PUBLIC PLANNING SUBMISSION: AMENDED DEVELOPMENT OBJECTION

Application: State Significant Development – 138 Maroubra Road (SSD-81426710)

Perspective: Surrounding Community Members & Adjoining Residential Neighbors

ADDITIONAL SHADOW
CAST BY PROPOSED
DEVELOPMENT

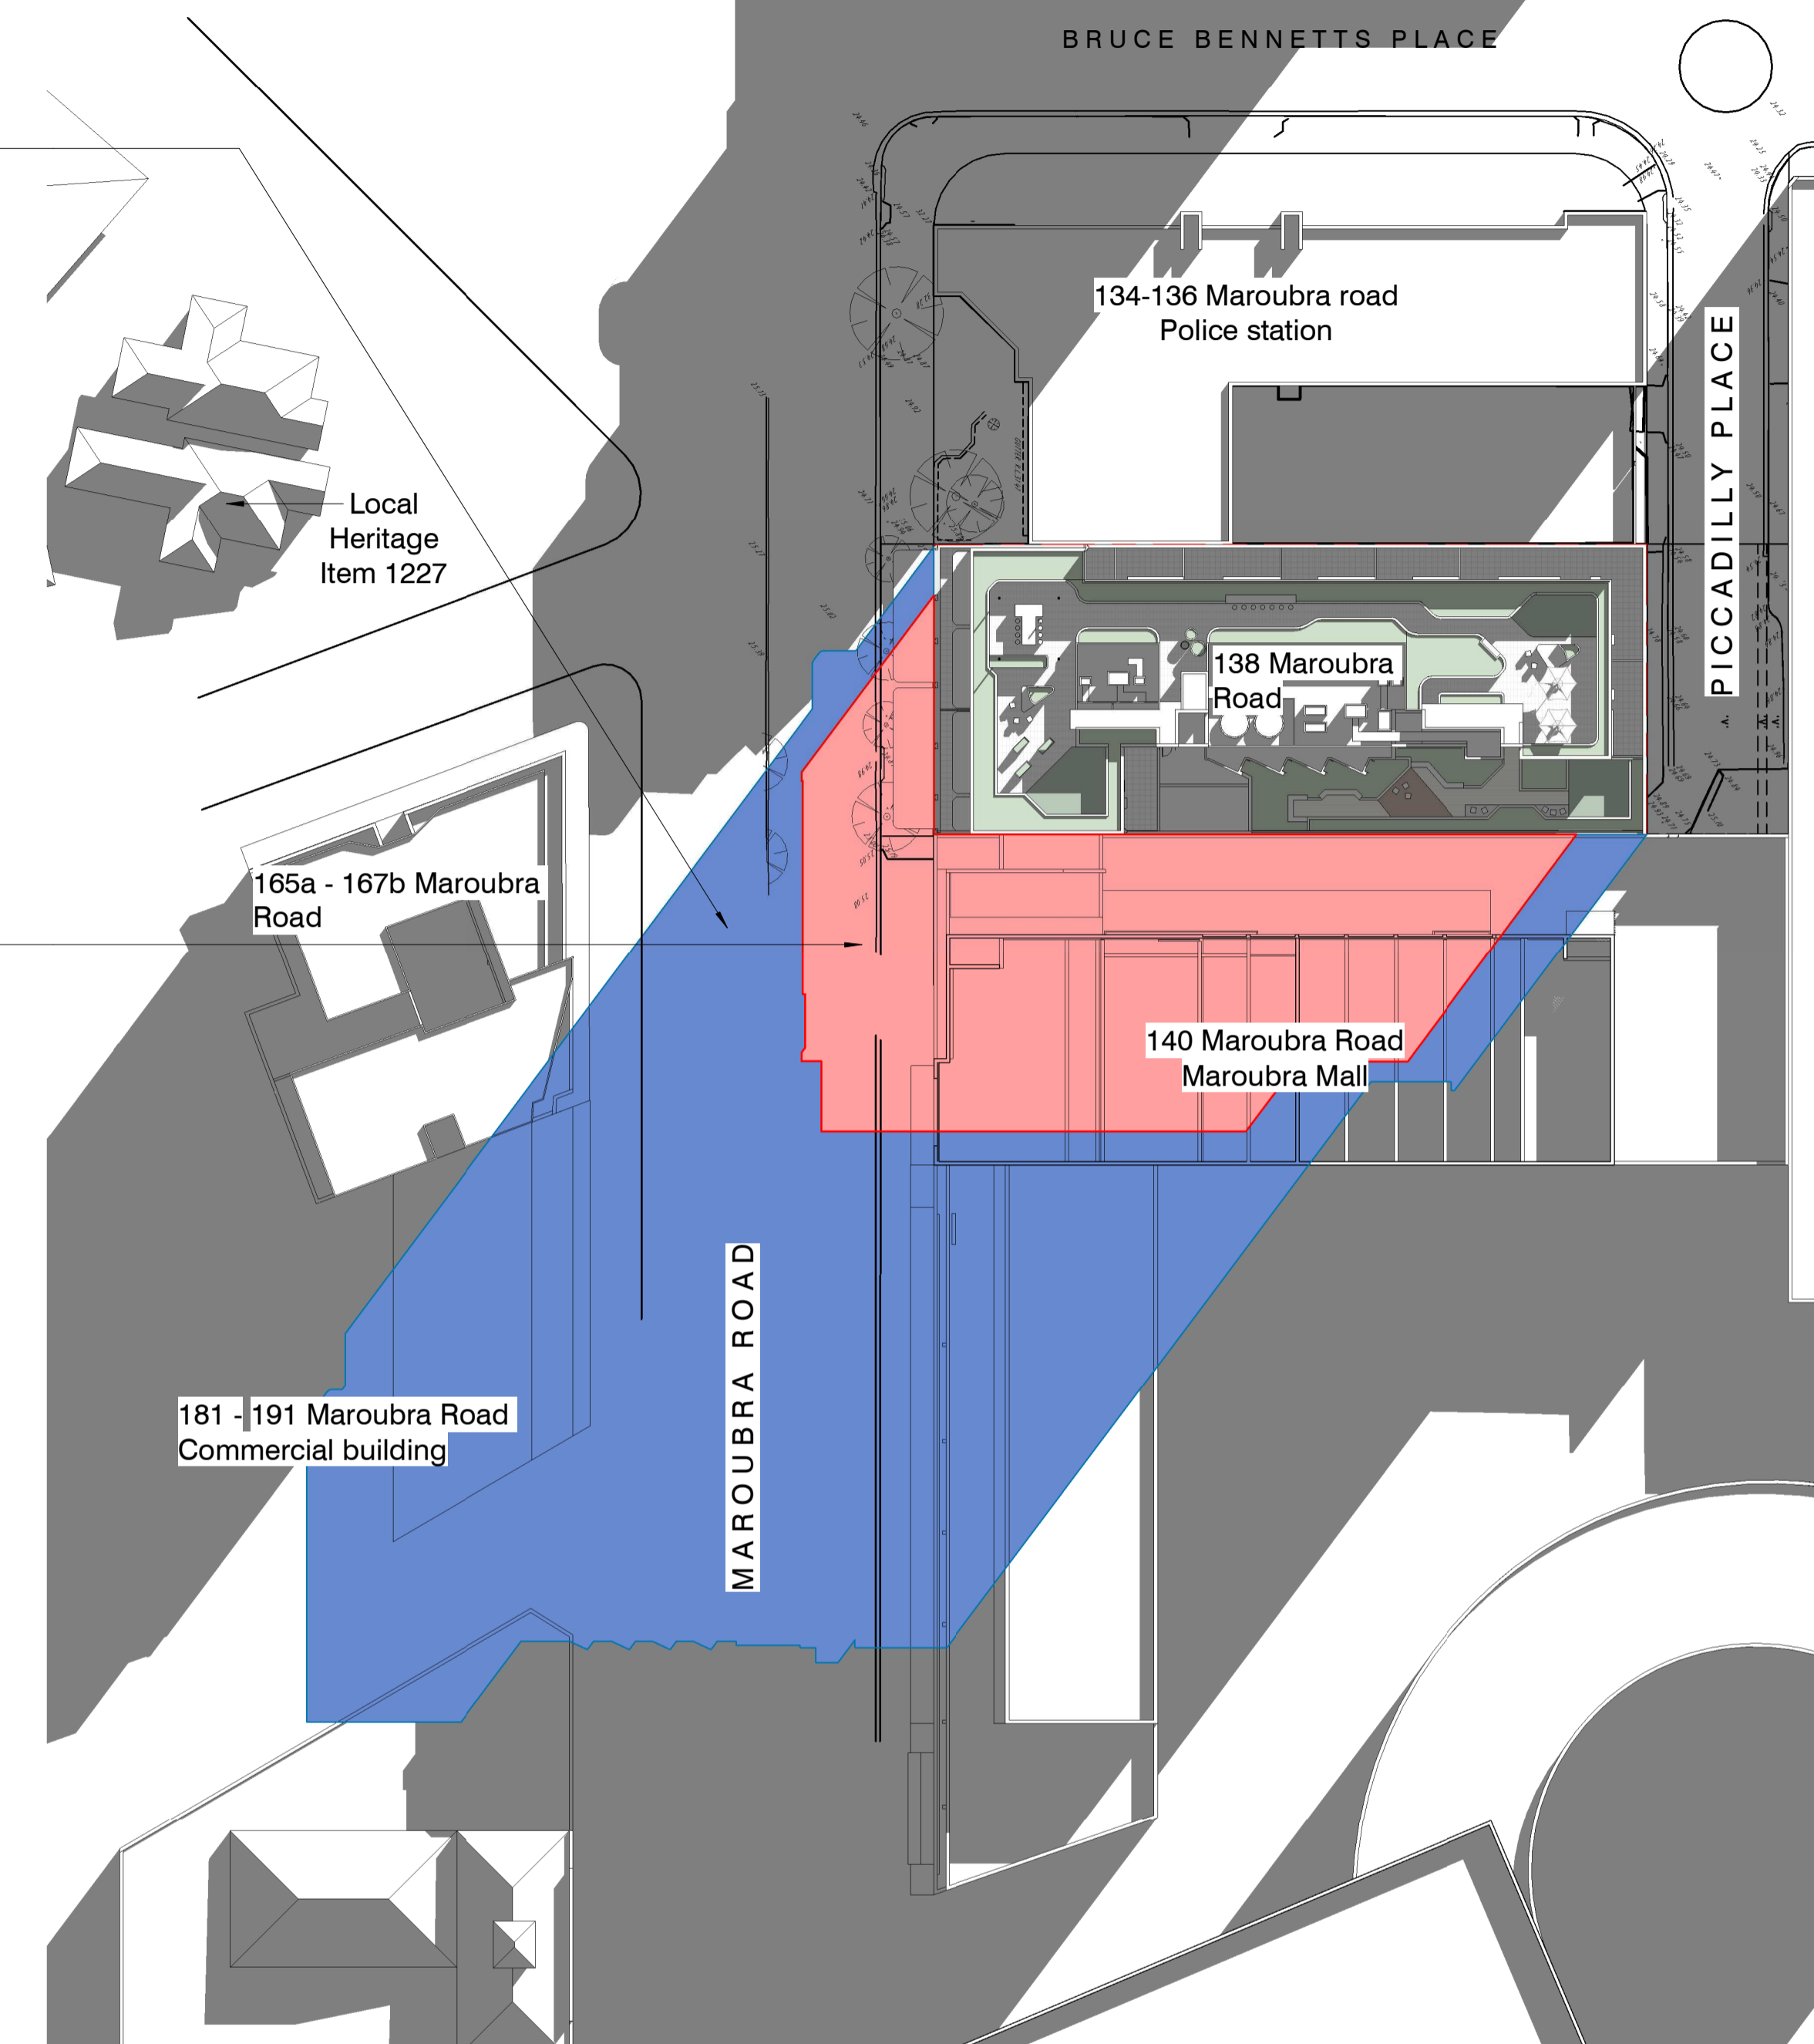
Afternoon Solar Deprivation and Extreme Microclimatic Shadowing on Adjoining Homes

The developer's updated shadow modeling relies on broad regional averages under the Apartment Design Guide (ADG), ignoring the direct microclimatic reality of neighboring properties. Constructing a deep, unarticulated 10-storey concrete envelope right to the boundary line completely blocks essential afternoon daylight.

Natural light is a crucial component of local living standards and natural apartment warmth. Depriving surrounding homes of afternoon sunlight degrades the well-being of neighboring residents. This impact is disproportionately borne by the high concentration of less-mobile senior citizens living in the adjacent building who stay indoors and depend heavily on natural sunlight for physical health and daily warmth.
